Recommendation Report for Planning Permission for Works or Extension to a Dwelling

REF NO: EG/63/18/HH

LOCATION: 40 Elm Grove
Barnham
PO22 0HL

PROPOSAL: 2no. front extensions, new roof to include accommodation at first floor level & internal alterations throughout.

SIDE ELEVATION
(west) 1:100

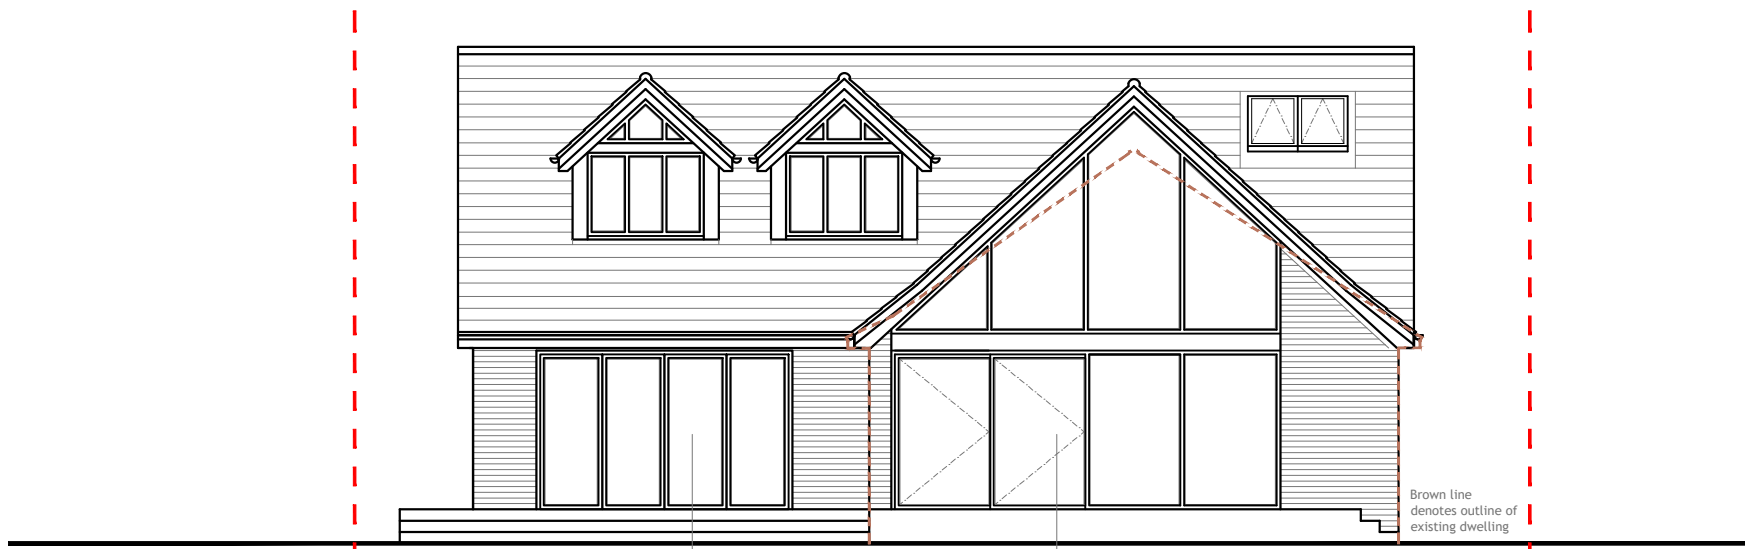
The development consists of extensions which would project forward of the principal elevation of the dwelling. However a minimum of 9.4m is retained to the front boundary and due to the siting of the dwelling it does not extend beyond the established property line in the locality.

As the proposal increases the total ridge height of the host dwelling, it cannot be considered a subservient addition and therefore is in conflict with DDM4(b), however the development does appear well integrated and as the surrounding area consists of a variety of design and styles with single and two storey properties the development is not out of keeping with the area.

The development consists of extensions which extend approximately 4.6m and 2.5m in front of the principal elevation of the dwelling with gable roofs to a height of around 5.7m. The proposal also creates rooms in the loft space by increasing the total ridge height of the host dwelling by approximately 1.3m, resulting in a total height of around 6.2m. Eaves height will remain as existing.

There will be 2 dormers to the rear with a height and depth of 2m which may have the potential for slight overlooking to the property to the north east, however as the windows do not serve principal rooms (landing and bathroom) the impact of any potential overlooking would not result in such harm that a refusal could be justified.

There will be a window and sliding doors to the eastern and northern elevation however at single storey level, views will be of the rear garden. There will be also 4 velux windows installed to the side elevations however due to their location in terms of the height in that they are above 1.7m from the finished first floor level, they are not considered to give rise to any loss of privacy or overlooking. 6 velux and a large set of windows are proposed to the 1st floor rear elevation however they serve a void area and therefore again are not considered to give rise to any overlooking.

Solar panels are proposed to the front gable roofs however due to their siting are not considered overbearing and with sufficient boundary treatment to the front side boundaries it largely restricts any view of the development and solar panels from the neighbouring properties.
